**Office of
Environment
& Heritage**

Your reference: 08_0200 (MOD 3)
Our reference: DOC14/171279
Contact: Kelly Roche (02) 6659 8288

Re: Cobaki Residential Subdivision – Open Space – Modification 3

TITLE		PRECINCT 9 BORROW AREA EARTHWORKS PLAN			
TASK	BY	INITIAL	DATE	APPROVED	RPEQ No
REVIEW	CS		11.12.13		
DESIGN	CJE		11.12.13		
DRAWN	GS		11.12.13		
DRAWING NUMBER				YC0229-1E1-EW13	REVISION
					C

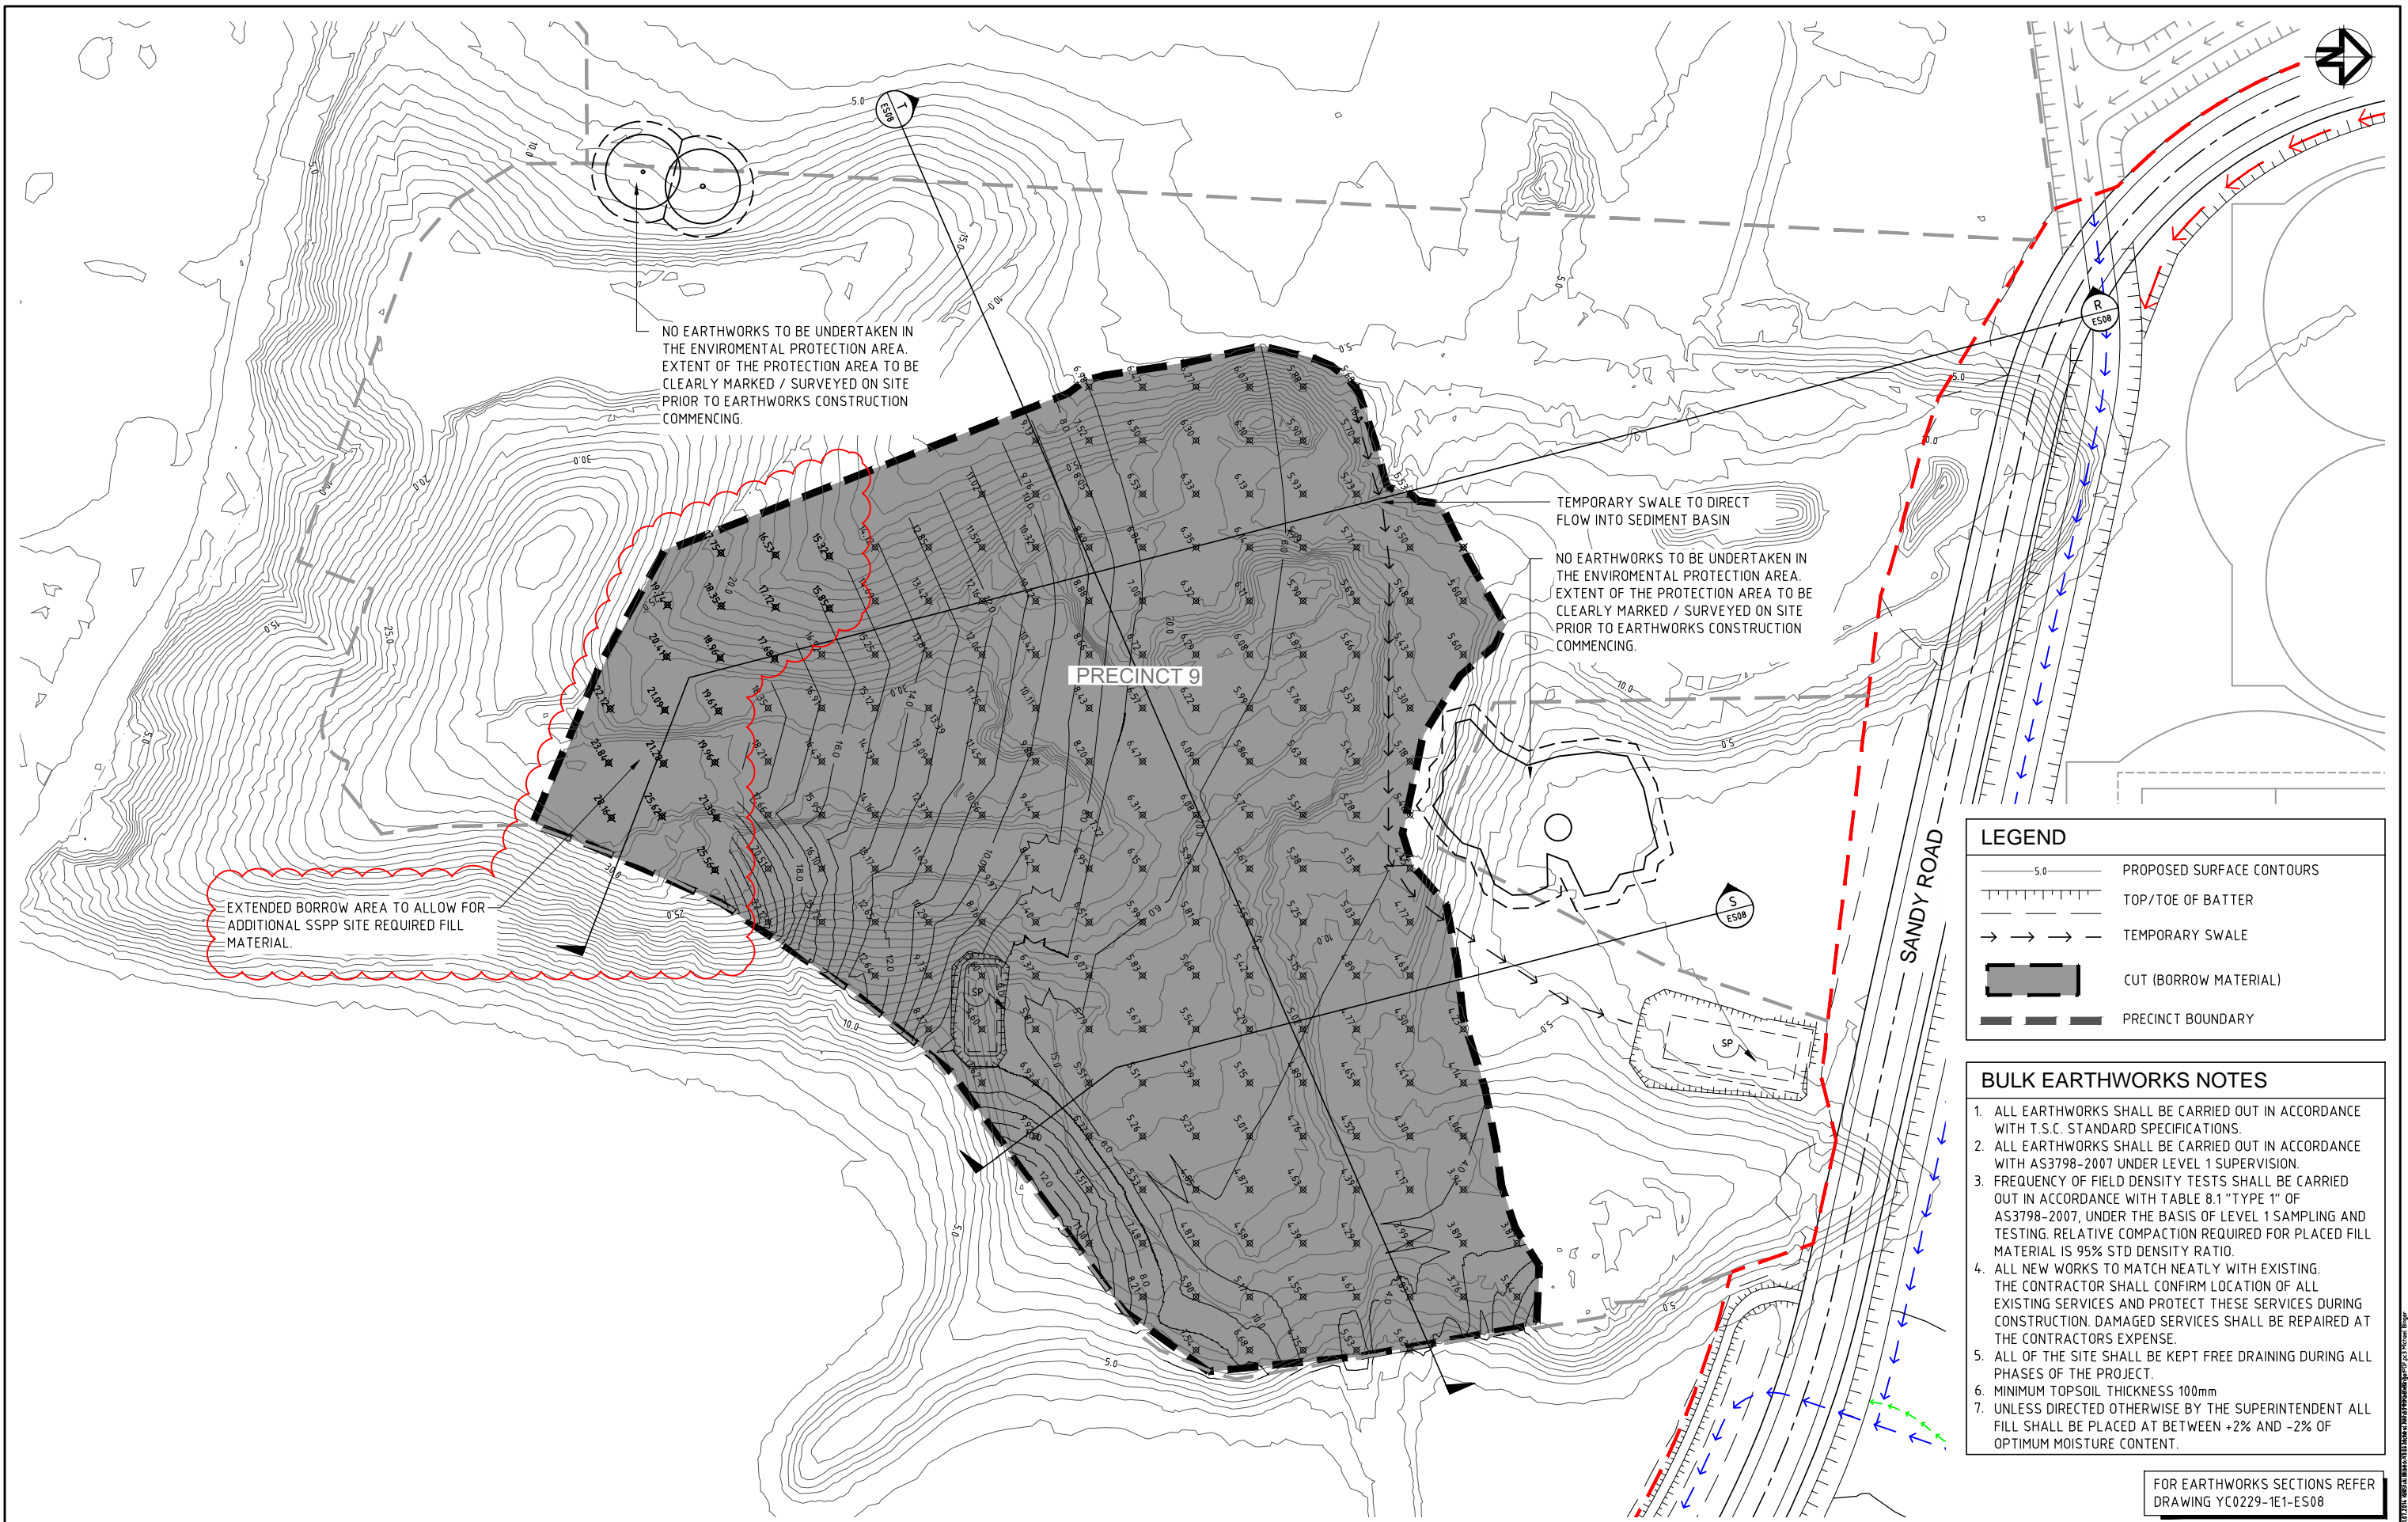
The modification documentation lacks clarity on the location and extent of the proposed borrow area in Precinct 9, from which over 180,000m³ of material is to be extracted. The potential direct and indirect impacts of the proposed modification works to the environment that could result do not appear to have been adequately considered.

Specifically, the Environmental Assessment Report (EAR) (Revision 1, dated July 2014) does not define the boundary of the extraction area and is silent on the potential biodiversity impacts associated with this component of the proposed works. Similarly, the Construction Environmental Management Plan (CEMP) makes no specific mention of the borrow area and how it is proposed to be managed.

The lack of reference to the location, extent, biodiversity features or environmental safeguards associated with the proposed borrow area makes it impossible to determine the relevance, effectiveness and adequacy of any management, mitigation and/or offset regime. OEH recommends that these matters be clarified to facilitate assessment of biodiversity impacts and formulation of appropriate environmental safeguards, mitigation and offset strategies prior to determining the proposed modification.
